MP 10_0111

**ENVIRONMENTAL ASSESSMENT FOR
INNER WEST LIGHT RAIL EXTENSION & GREENWAY**

**SUBMISSION BY MARRICKVILLE COUNCIL
TO THE DEPARTMENT OF PLANNING
ON THE ENVIRONMENTAL ASSESSMENT FOR THE
INNER WEST LIGHT RAIL EXTENSION & GREENWAY**

Figure 10.2a Construction access routes

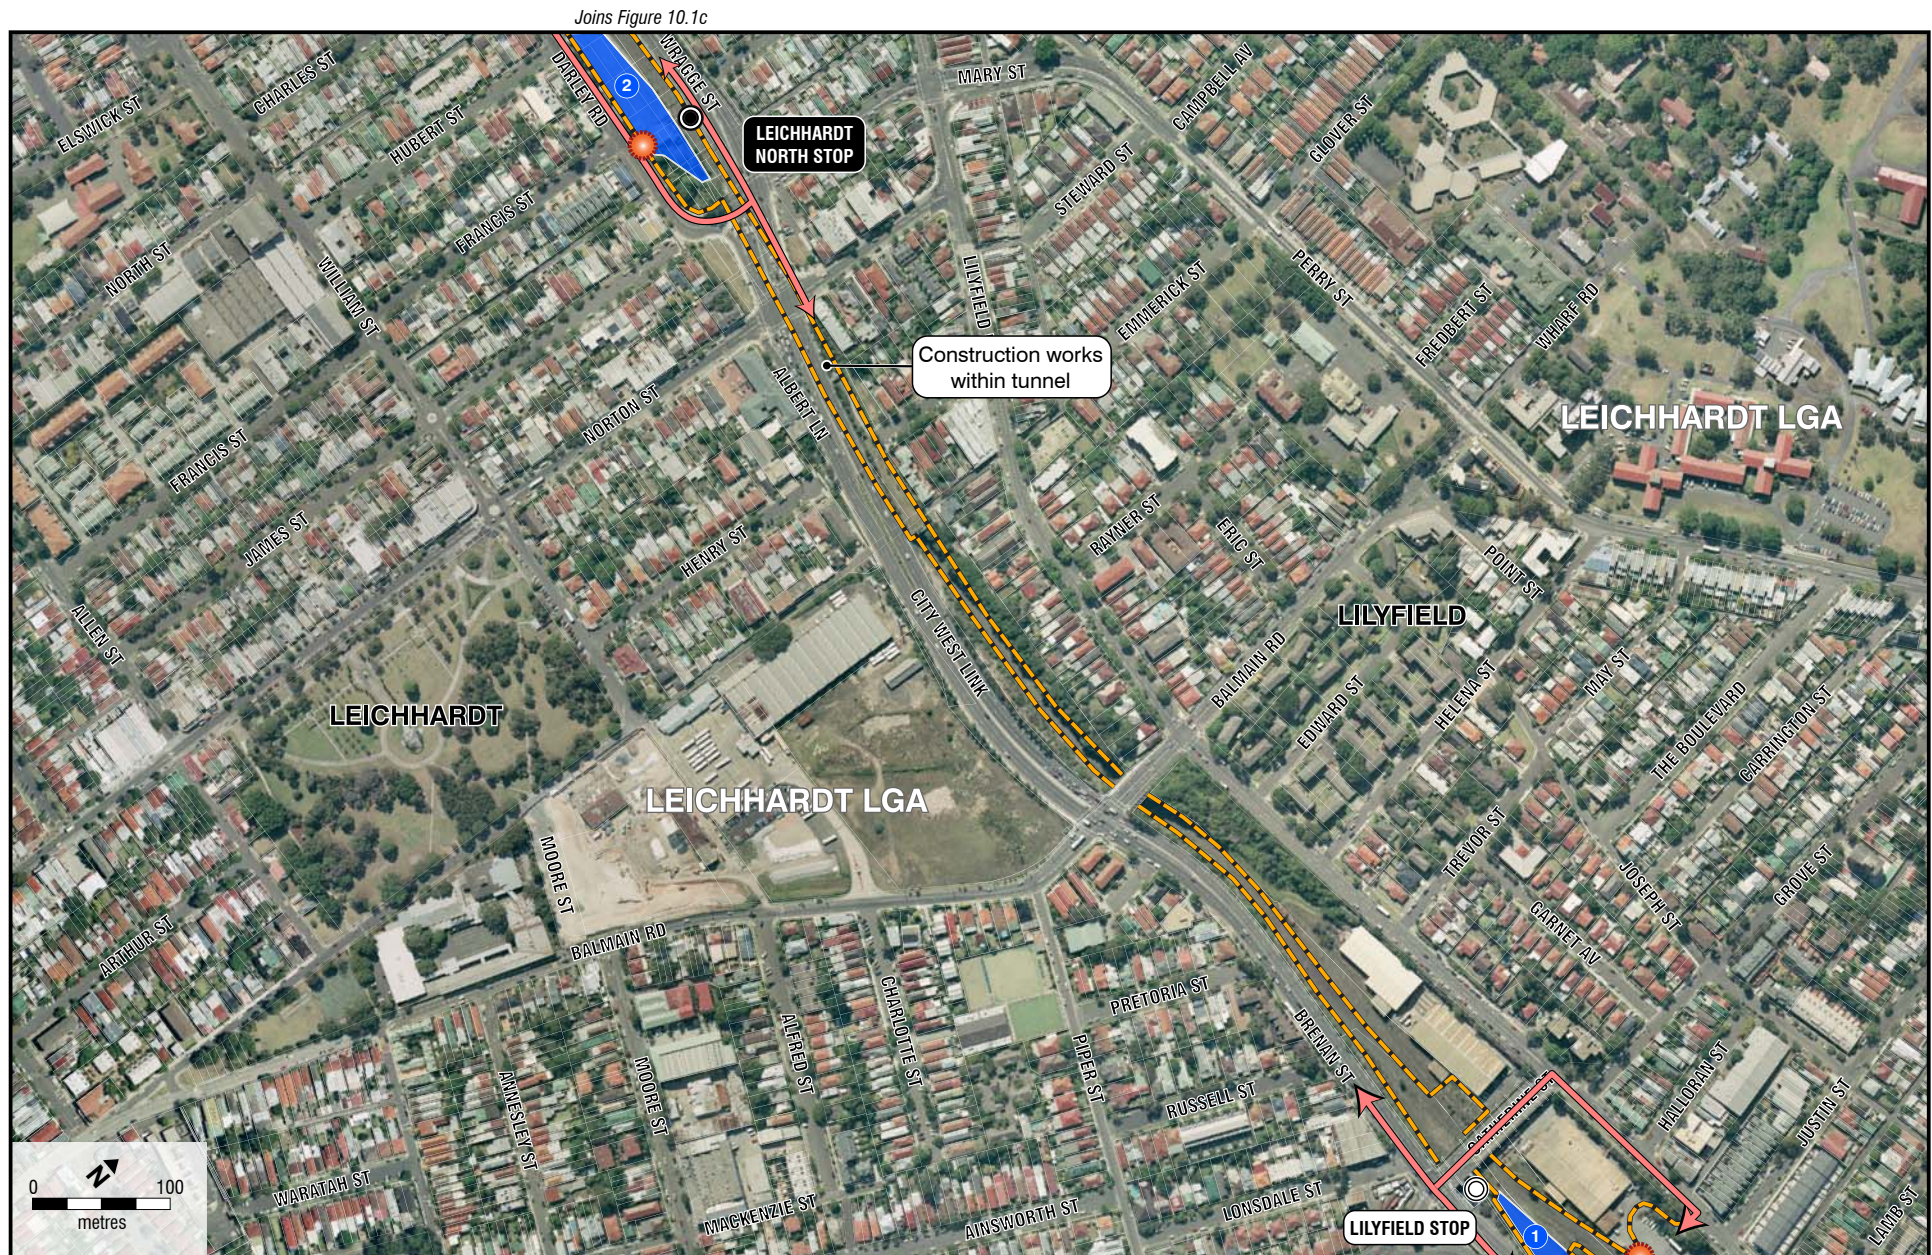
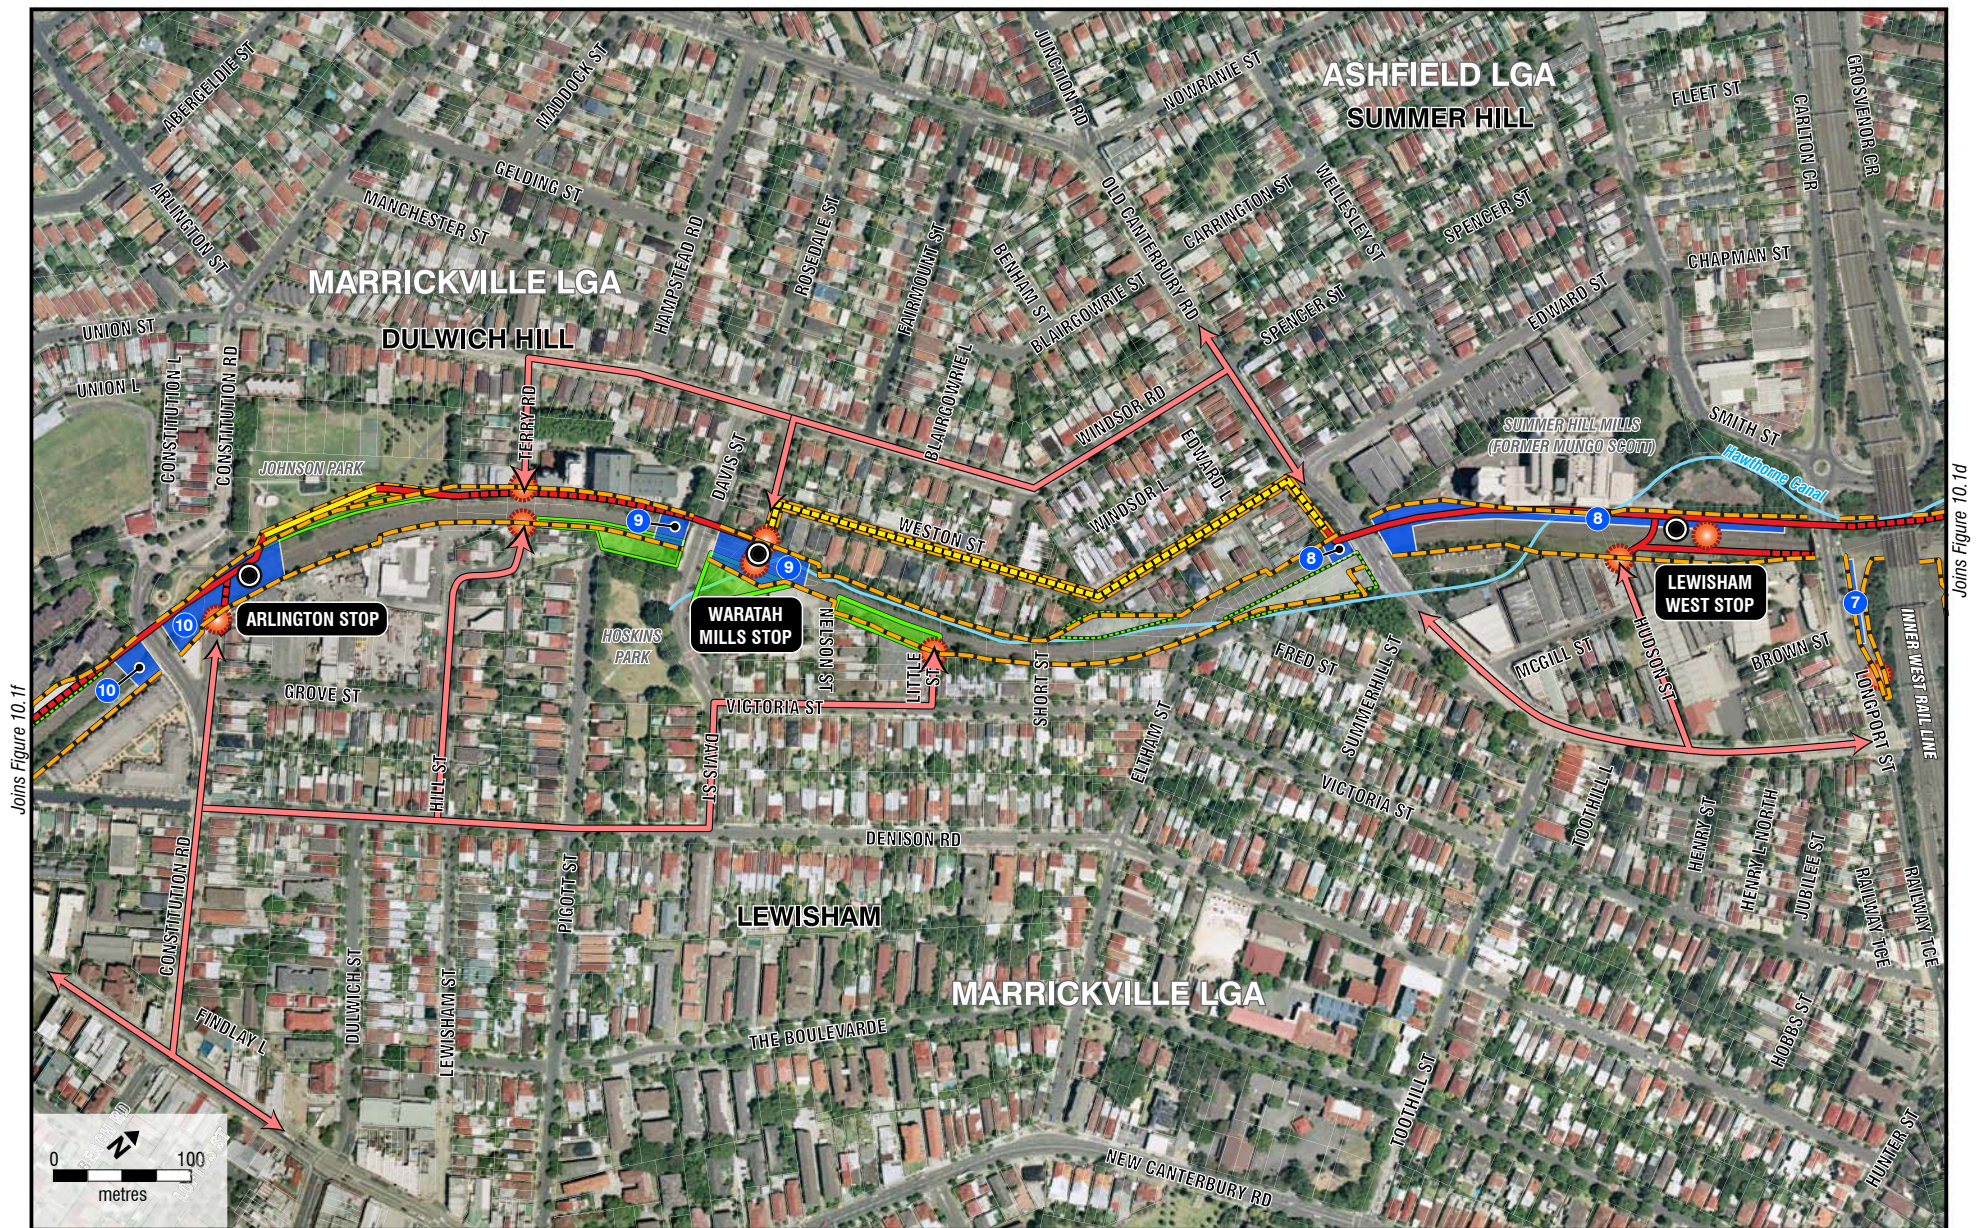
- *Section 10.4.3 of Volume 1 - Main Report* refers to Figures 10.2a to 10.2g. There is no Figure 10.2g in the document. It is assumed this is a typo instead of a missing figure in the report.
- *Table 3.12 of Technical paper 1* indicates that Brown Street, Hathern Street and Cook Street are Local Roads. Brown Street and Hathern Street are State Roads as is the section of Cook Street between Brown Street and Old Canterbury Road. Tebbutt Street is also a State Road between Brown Street and Parramatta Road.

**Figure 2 – GreenWay between Waratah Mills and Lewisham West Light Rail Stops**

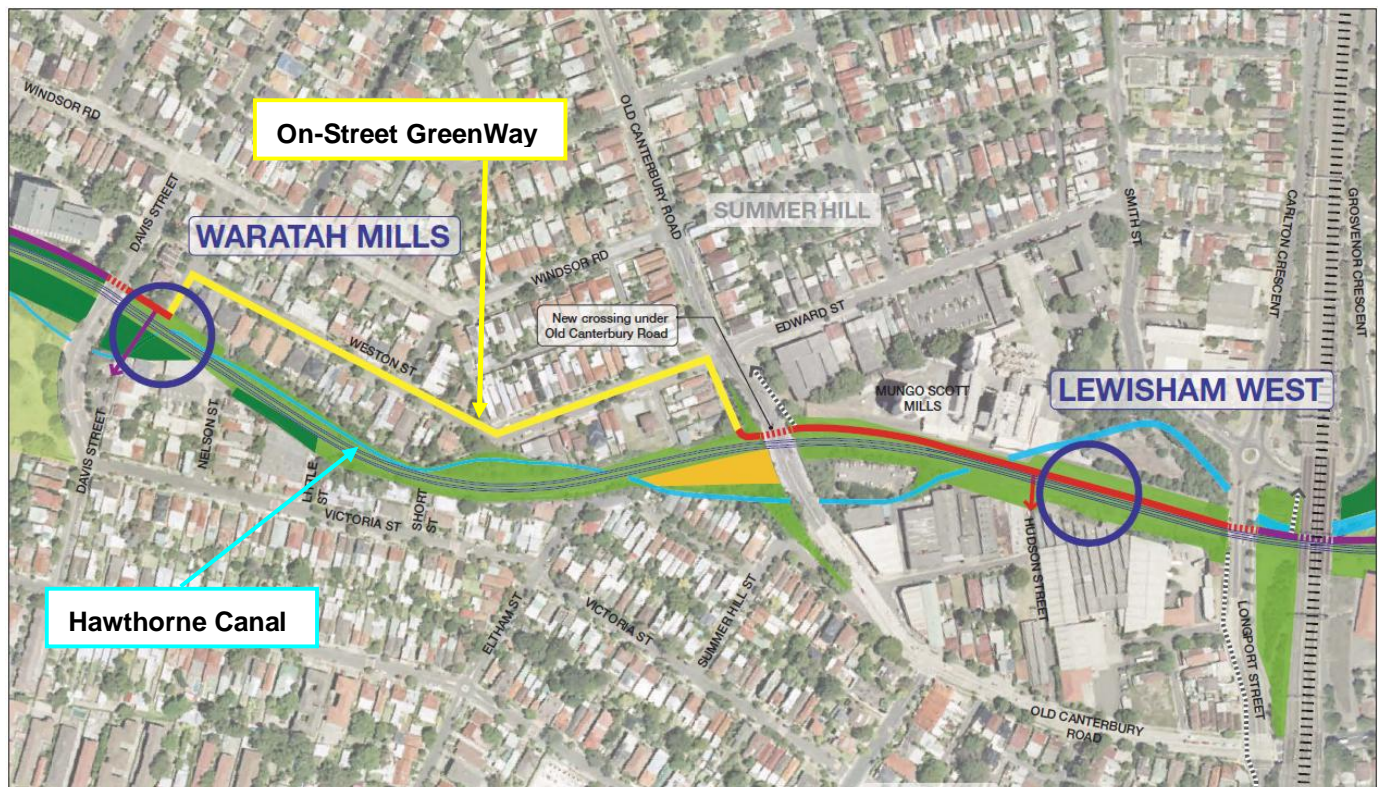
Issue 4: Council would like to see further consideration of the option of constructing the GreenWay walk/cycle path within the corridor between Waratah Mills Station and Old Canterbury Road instead of along Weston Street – as has been previously advocated by Council and Weston Street residents;

When Council considered the PEA at its 10 August 2010 meeting, it resolved to make a submission on the PEA and added a resolution that: “the submission state that Council’s preferred option is that the GreenWay remain in the existing corridor.” Whilst Council does recognise the issues involved, i.e. narrow corridor width, flooding, privacy impact, construction feasibility and construction cost, its position remains on this matter. Weston Street residents have attended recent meetings at Council in relation to the EA to discuss this matter directly with Council and the Transport NSW project team. It is apparent that most Weston Street residents continue to support the ‘within corridor’ option. At one of the meetings, residents raised the prospect of the NSW Government acquiring sections of residents’ back yards to enable the path to be constructed. If all residents were in agreement, this could be undertaken through an agreed sale rather than a forced acquisition, and it could be assumed that the modest cost of this narrow strip of land would not add significantly to the overall cost of the project.
